WEST SUSSEX COUNTY COUNCIL CONSULTATION

TO:	Arun District Council FAO: Andrew Wood
FROM:	Highways, WSCC
DATE:	04/01/2019
LOCATION:	Land Adjacent to Elm Lodge, Tamarisk Way, Ferring, West Sussex
SUBJECT:	FG/220/18/PL Erection 1 No. dwelling with integral garage
DATE OF SITE VISIT:	N/A
RECOMMENDATION:	☒ Advice ☐ Objection ☐ Modification ☐ No Objection ☐ More Information ☐ Refusal
S106 CONTRIBUTION TOTAL:	£N/A

PROPOSED COLOURED SITE PLAN AT 1:100

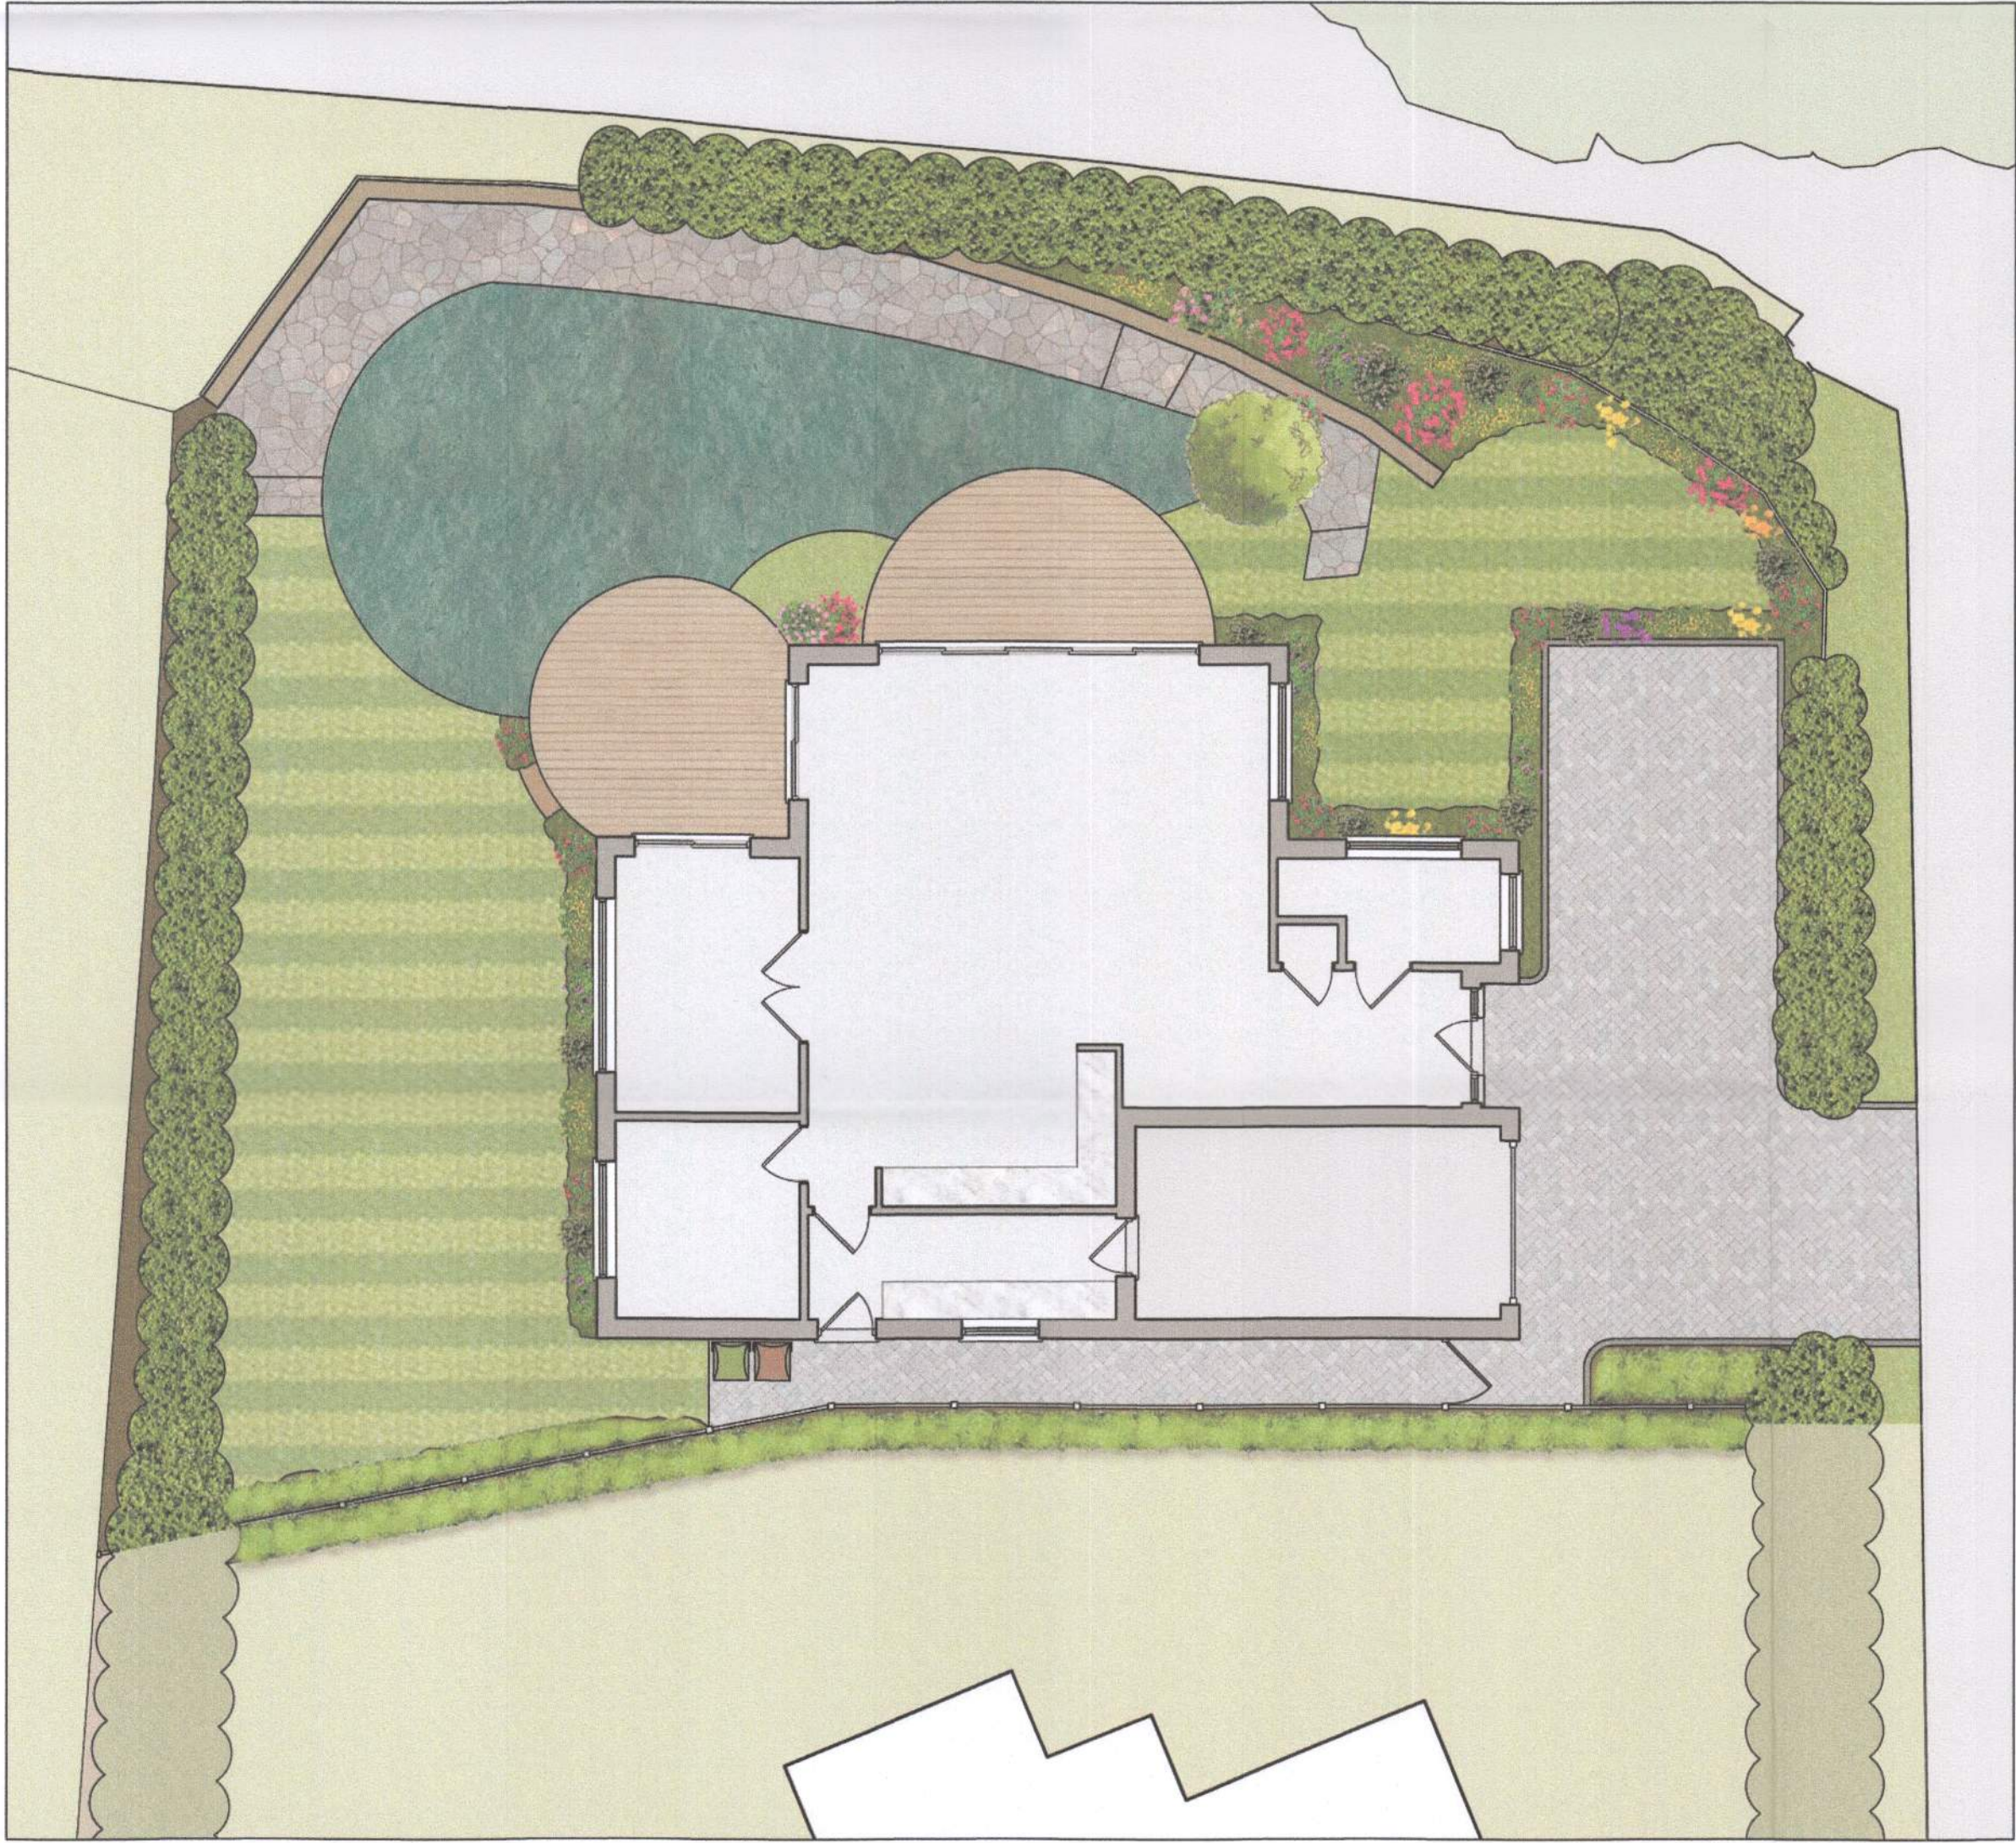
The plans indicate that a new access to the site is proposed for Tamarisk Way. The applicant should obtain formal approval from the proprietor of the private lane to carry out any site access works.

The proposed plans indicate that two off-street parking spaces will be provided for the proposed dwelling and an integral garage. The proposed plans demonstrate internal dimensions of 3 x 5.8m. In order to be counted towards parking provision for the dwelling, the minimum internal dimensions should meet Manual for Streets guidance of 3 x 6m. The applicant is advised to consider increasing the proposed garage depth to meet these minimum internal specifications. However, this is not anticipated to cause a highway safety concern in this location. This is anticipated to be sufficient parking provision for a dwelling of this size and location. A turn on site would be preferred however there is clearly insufficient space on site to accommodate this. However, neighbouring properties have similar arrangements and operate without evidence of safety concern.

No part of the development shall be first occupied until the car parking has been constructed in accordance with the approved site plan. These spaces shall thereafter be retained at all times for their designated purpose.
